Consultation Response from KC Waste Strategy
2025/91579 The Homestead, Hurst Knowle, Almondbury, Huddersfield, HD5 8SG
Demolition of the former Homestead care home and erection of 28 dwellings, comprising 20 apartments and 8 bungalows, with access from Hurt Knowle and associated external works including landscaping
Date Responded: 28/10/2025 Responding Officer: Alan Smith Responding Ref: WPS 25 050

APARTMENT BIN STORE

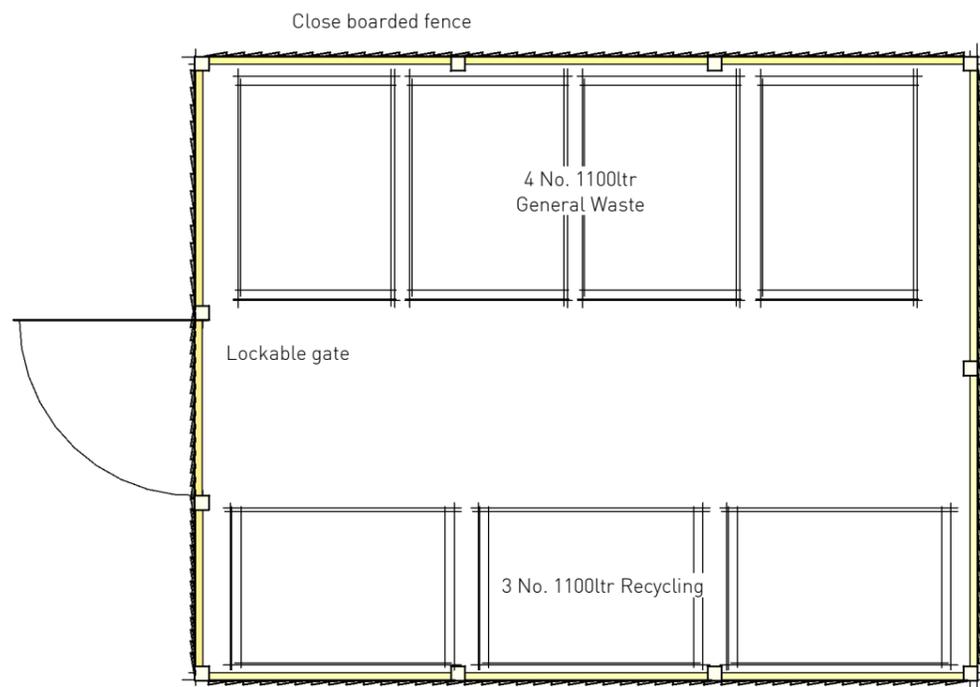
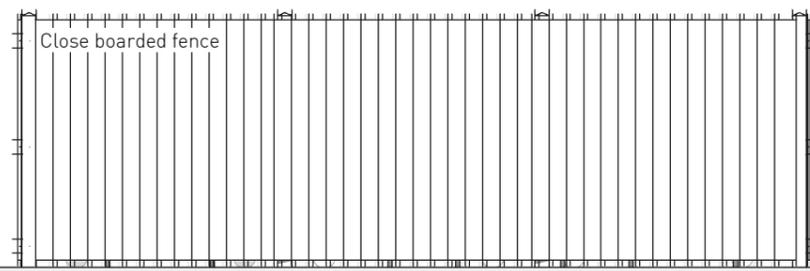
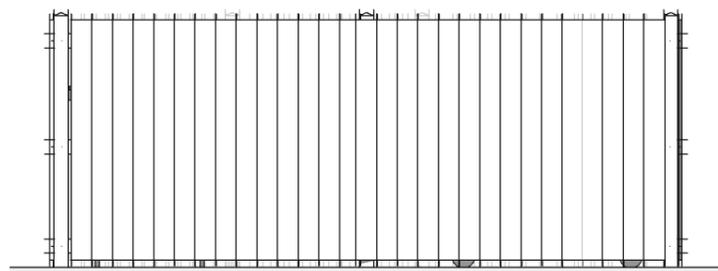
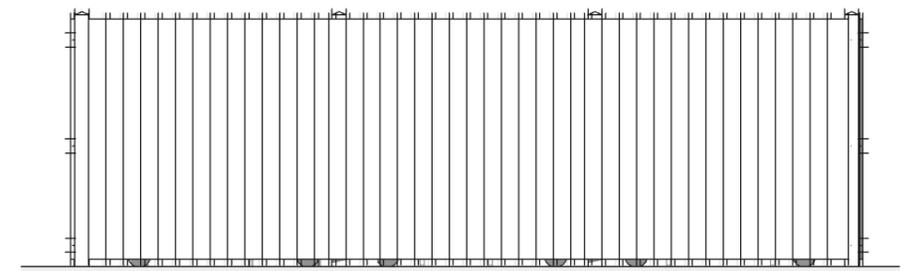
A revised drawing of the apartment bin store shows space for 7 x 1,100L bins, but the layout is smaller than originally proposed and requires bins to be stored end-on. This configuration prevents residents from identifying bin types, which is problematic, especially with upcoming Simpler Recycling legislation requiring further waste separation. Additionally, this configuration allows no provision for future food waste containers.

The bin store needs to be made larger so that waste containers can face forwards.
